**WEST SUSSEX COUNTY COUNCIL
PLANNING SERVICES CONSULTATION**

SUBJECT: BN/32/17 DOC - Application for approval of matters reserved by condition imposed under BN/16/12/ (APP/C3810/A/13/2193942) relating to conditions 5-surface water drainage, 6-maintenance of SUDs, 7-foul drainage system, 8-schedule of materials & finishes, 11-scheme for protection of retained trees, 13-plan indicating boundary treatments, 17-ecological enhancement measures, 18- mitigation & translocation plan for reptiles, 19-Ecological Clerk of Works for final bat checks & soft tree felling, 20-mitigation for noise sensitive facades & amenity areas, 21-pedestrian & cycle paths, 23-layout & specifications of & construction programme for roads, including access, footpaths, foul & surface water drainage & means of disposal, 25-pedestrian visibility splays & 26- Travel Plan.

Former Pollards Nursery, Lake Lane, Barnham, Bognor Regis, PO22 0AQ

Title: Engineering Layout Sheet 1 of 1

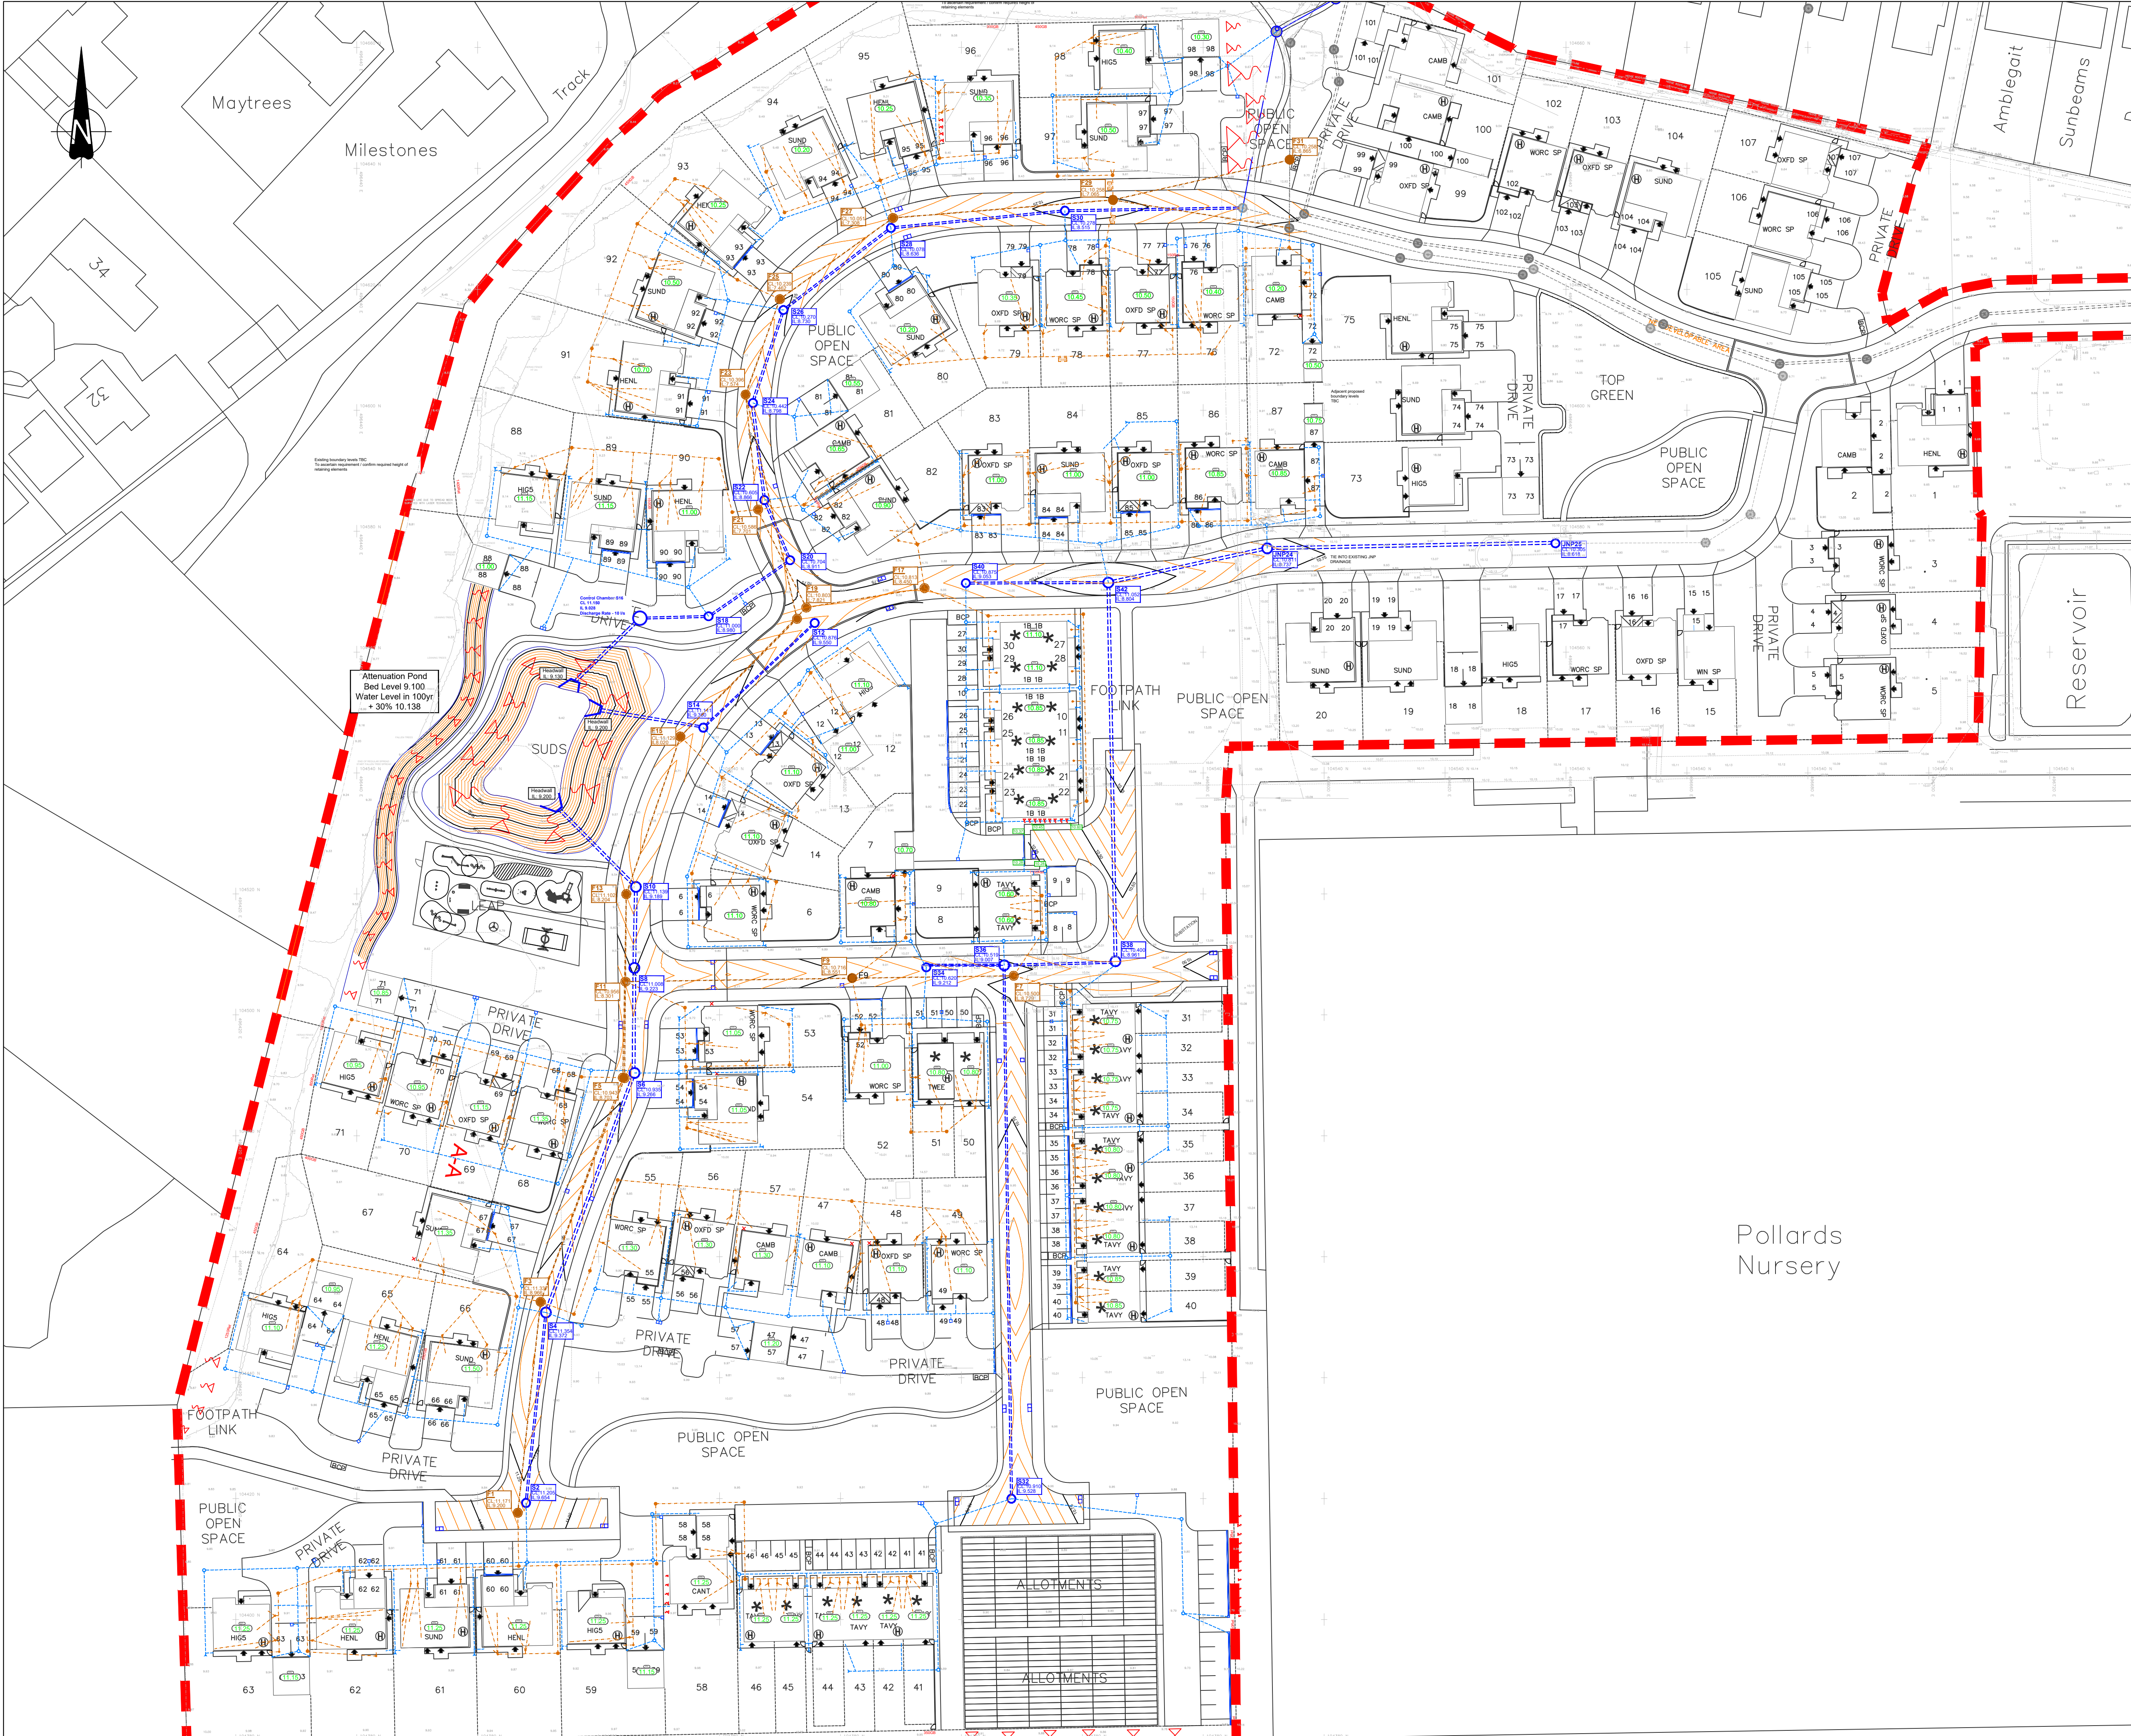
The site layout plan shows a 'footpath link' the planning condition requires a pedestrian and cycle link to the adjoining site.
